RE PLANNING APPLICATION FG/151/1

MAGPIES, 52 SEA LANE FERRING.

The erection of 1 large detached house and garage.

Demolition of existing large double garage & erection of 1no. detached dwelling house,
together with additional double garage for Magpies

3 Bedroom House
Ground Floor Plan

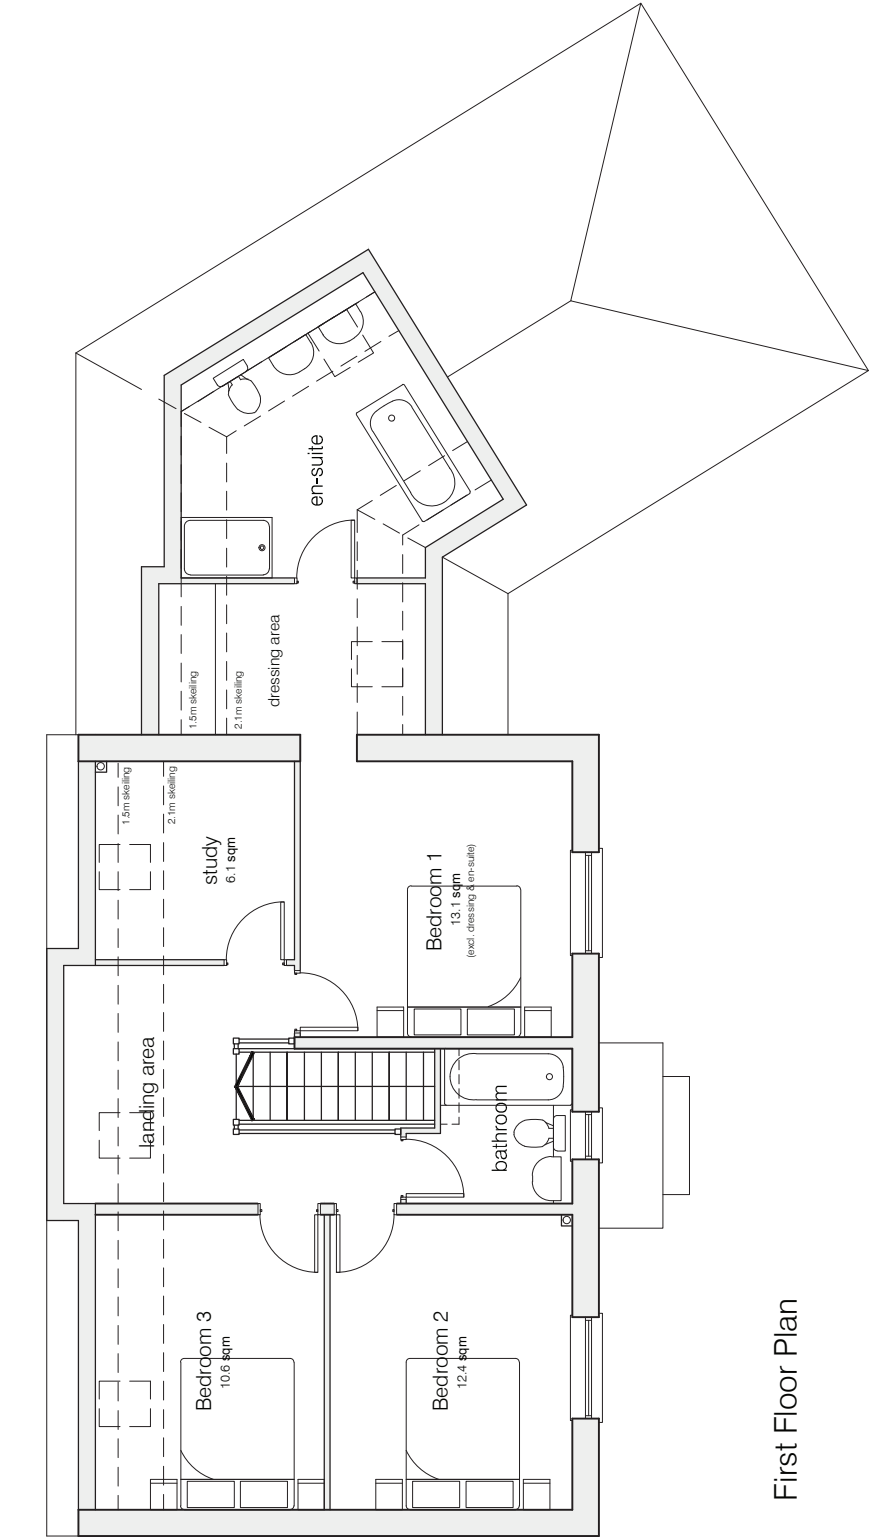
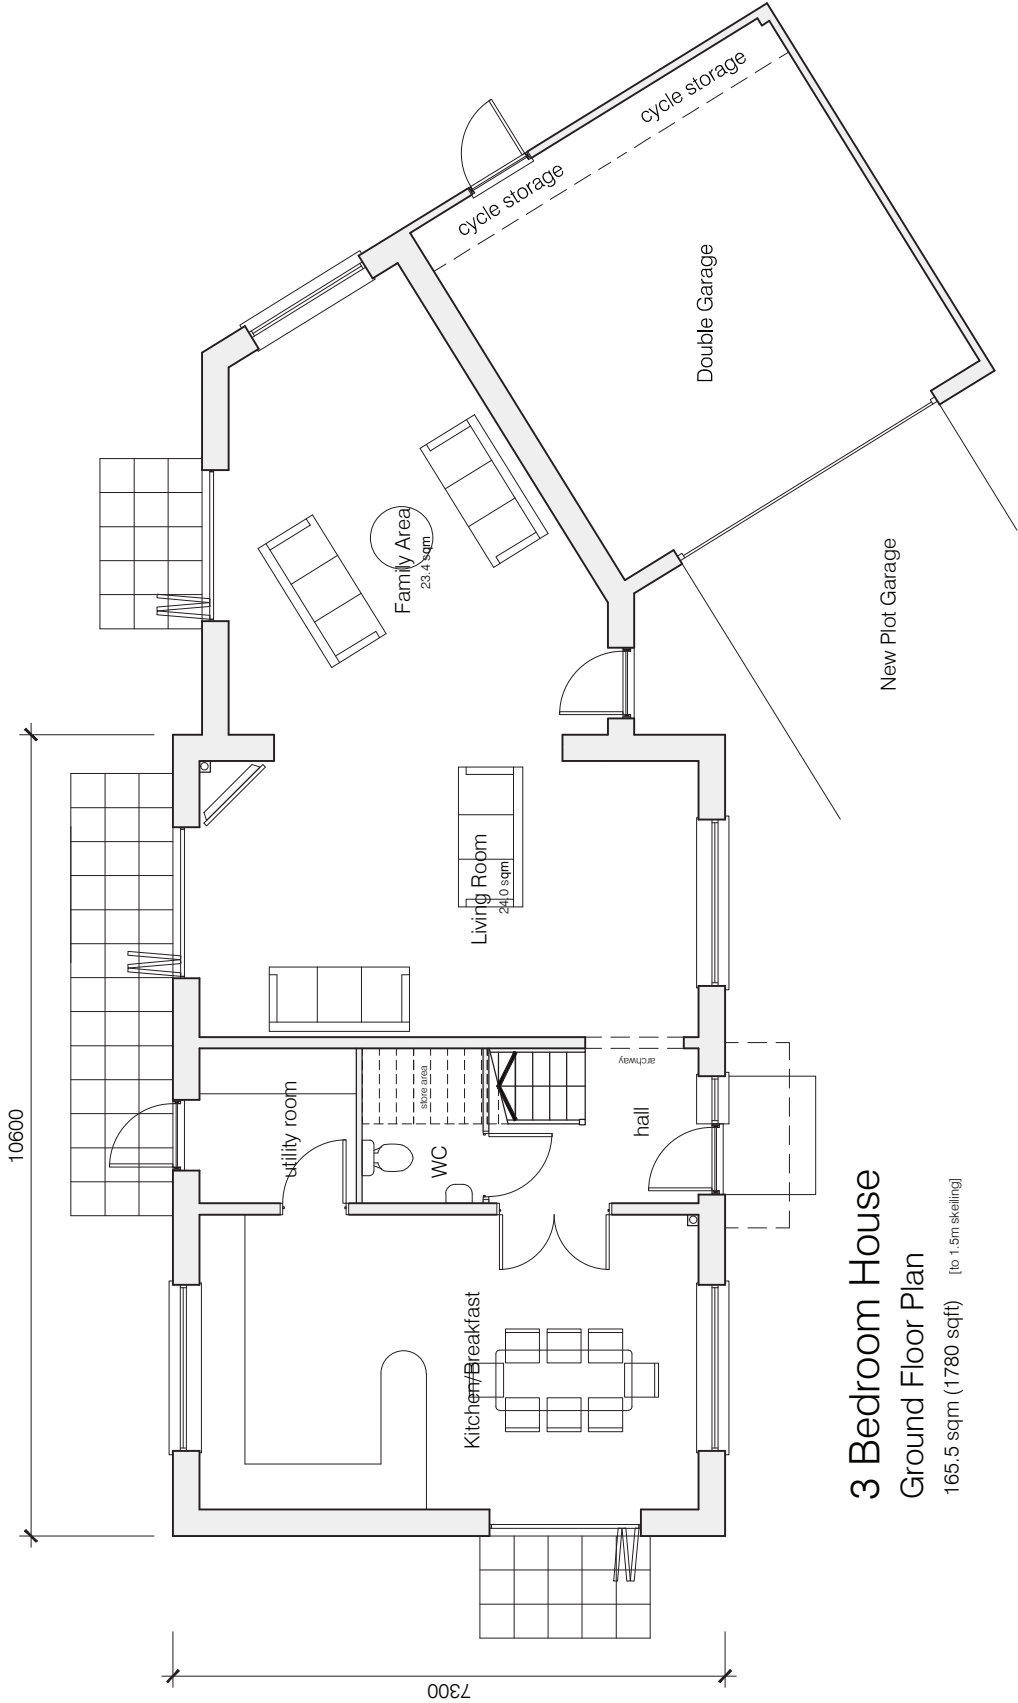
We object on the grounds that the proposed dwelling with the adjoining double garage is only 2 metres away from our side fence and would throw a large shadow over our garden and cut out a considerable amount of light. Moreover, the proposed large property would be cramped on such a small plot and detrimental to the character of the surrounding properties and therefore unneighbourly. Our view from the back of our house and garden would be blighted. Also to be taken into account is the extra traffic flow using the single shared driveway which would increase noise and pollution levels.

Rear (West) Elevation

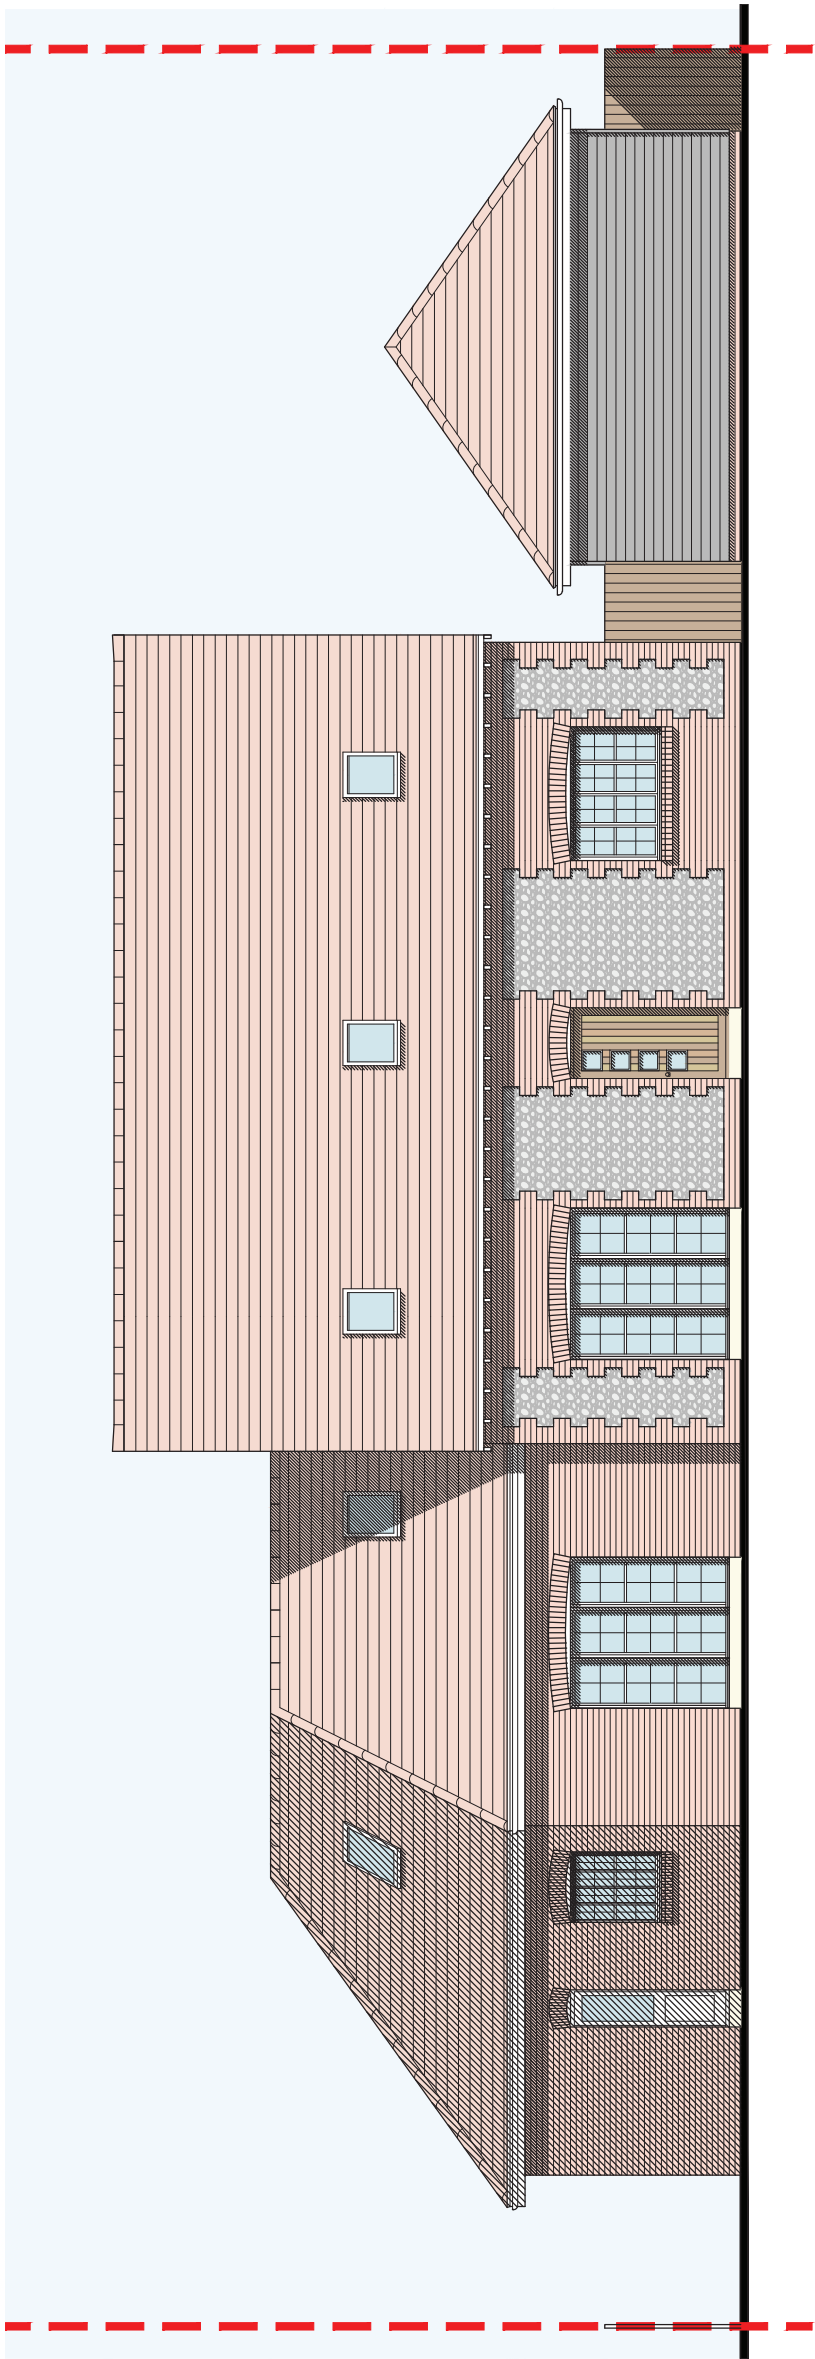
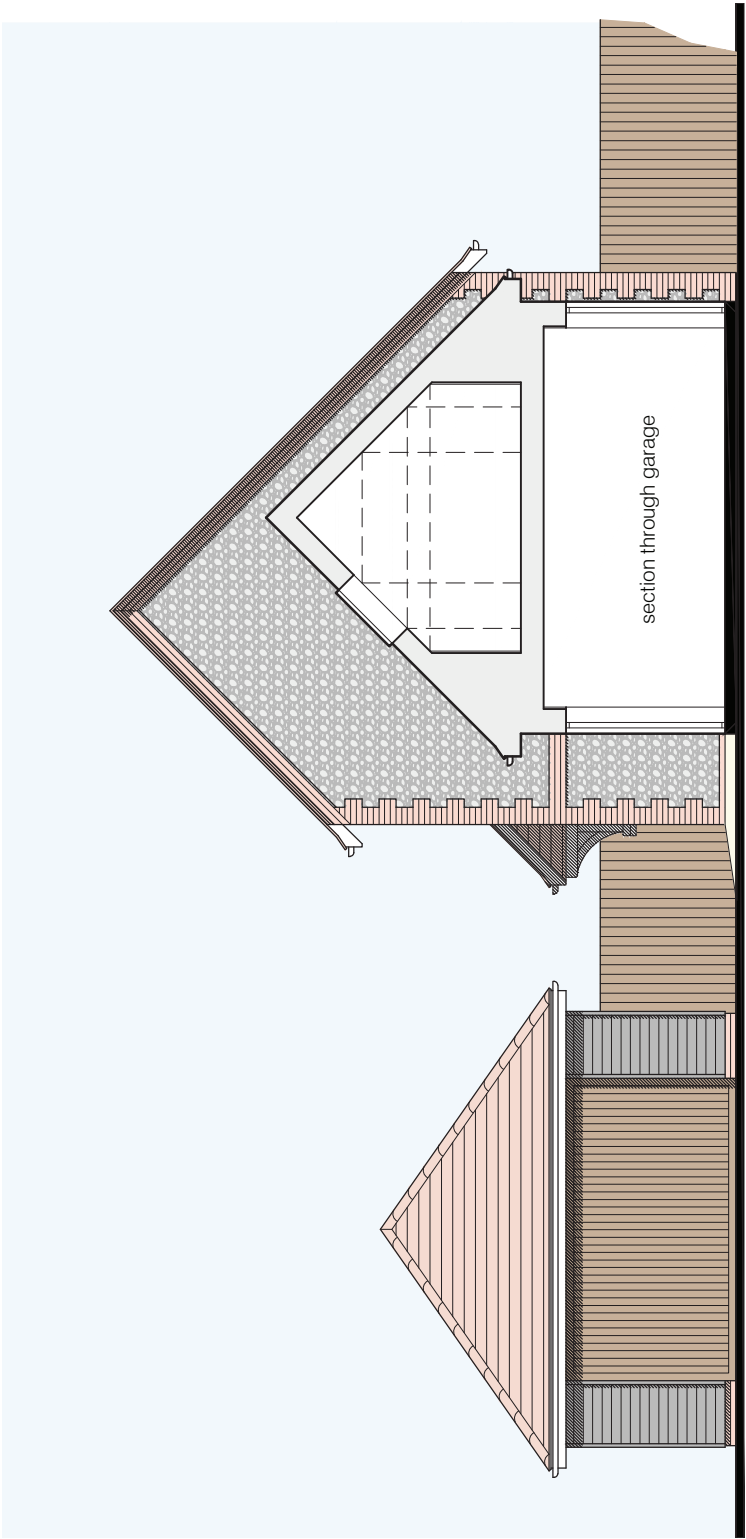
2. Whilst the plans claim to maintain appropriate distances from Magpies and No 50 Sea Lane, no such consideration appears to have been given to the properties to the west of the site. Both the new dwelling and the existing bungalows are close to the dividing boundary and the new dwelling would inevitably have a detrimental effect on the enjoyment and light available to the existing properties.

☐
1. The proposal would constitute an unsatisfactory form of backland development which would have an adverse affect on the privacy and quiet of the bungalows in Laburnum Close; particularly No.9 which it will be directly behind. The height of the proposed new building which is far higher than the application refused last year is excessive and much higher than the existing garages which are already too high at 5.9metres. Due to the height of the proposed development and the closeness to the boundary of 9 Laburnum Close, many windows in the proposed development will look directly into the garden, kitchen and living room of 9 Laburnum Close and therefore will be extremely detrimental to the privacy of this property. ☐

We plan to move to Ferring as soon as possible, but are put off many locations due to (in our opinion) unsympathetic over development. This large house is positioned so close to the bungalows in Laburnum Close that all their privacy will be lost. I feel that a single storey property, positioned a greater distance from the rear border of the plot would be more in keeping with the surroundings. Kind regards, Paul.
